From: Juan Baeza
Sent: 07 September 2017 15:22
To: 'sally henderson'
Cc: Planning.Responses; Anita Gardner
Subject: RE: FG/122/17/HH

From: sally henderson [REDACTED]
Sent: 05 September 2017 22:12
To: Andrew Wood
Cc: Juan Baeza
Subject: FG/122/17/HH

drawing Planning Applications
Proposed Elevations

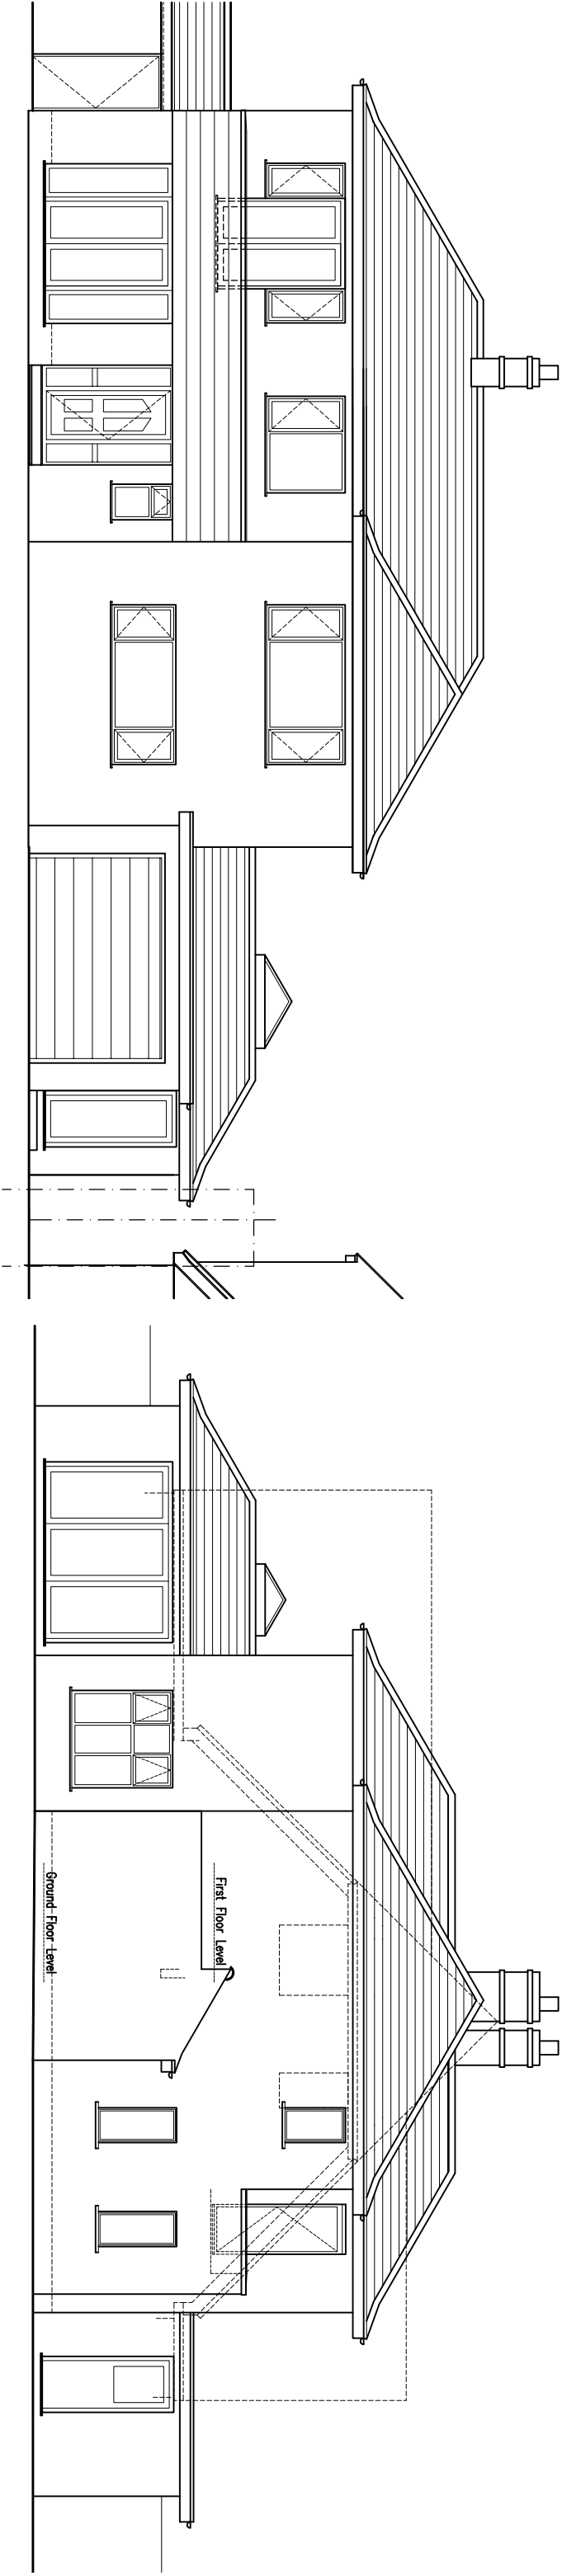
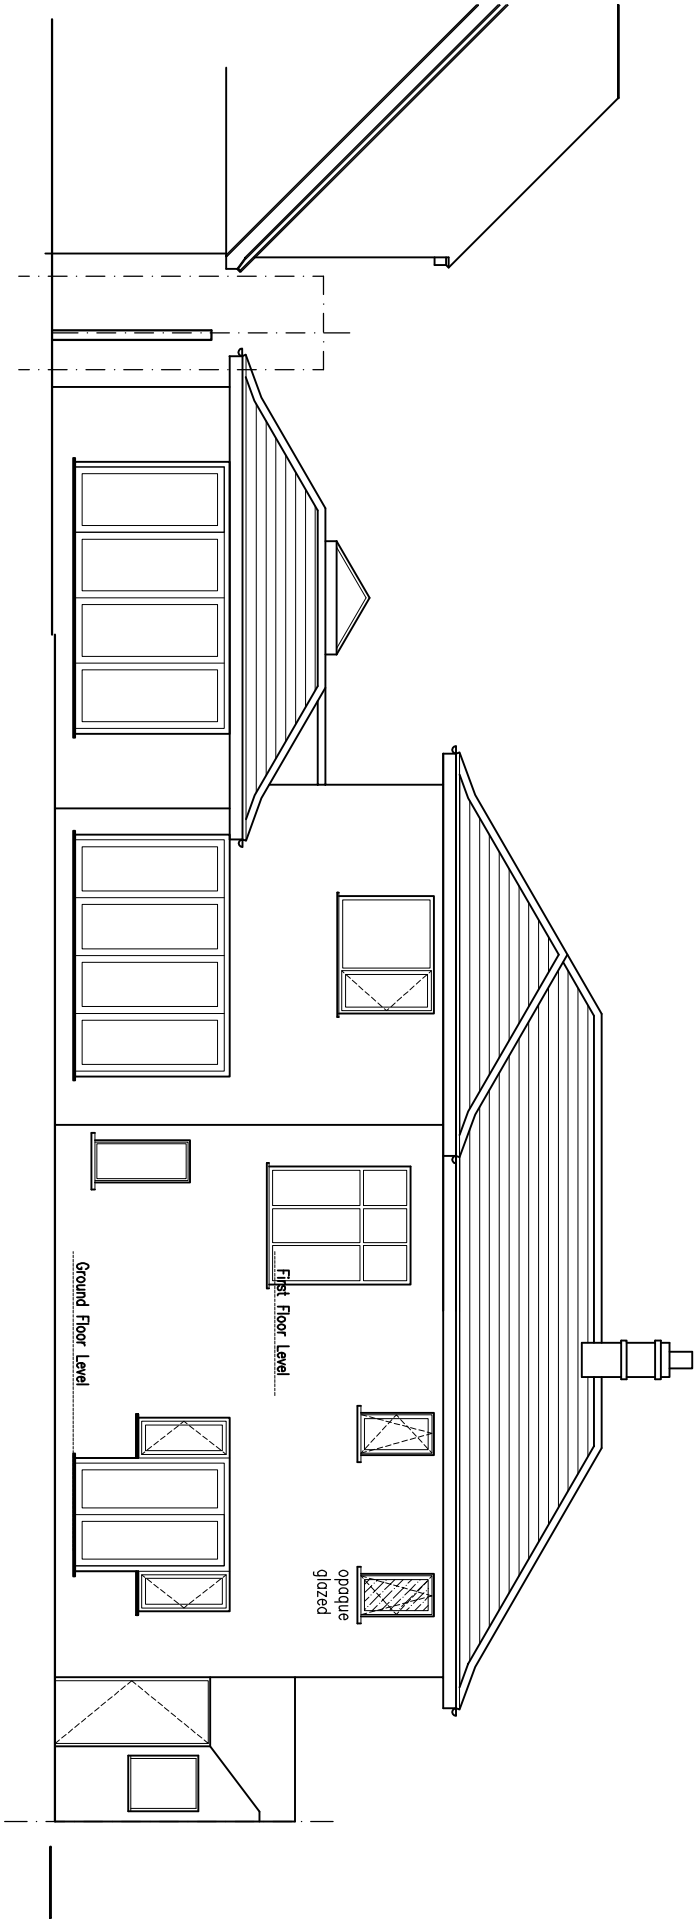
With reference to the above application, and further to my online submission of 14th August, please can you advise if the applicant has / will supply details of how their rear 2 storey extension will affect the light to the only window of our West facing bedroom, with respect to the 45 degree rule.

I understand that the council uses the 45 degree rule to assess overbearing impact of development on primary habitable room windows, and that if built development encroaches within a 45 degree sight line drawn from the closest habitable room window, then it is considered unacceptable in terms of causing an overbearing impact on the neighbour's window and a loss of light to them.
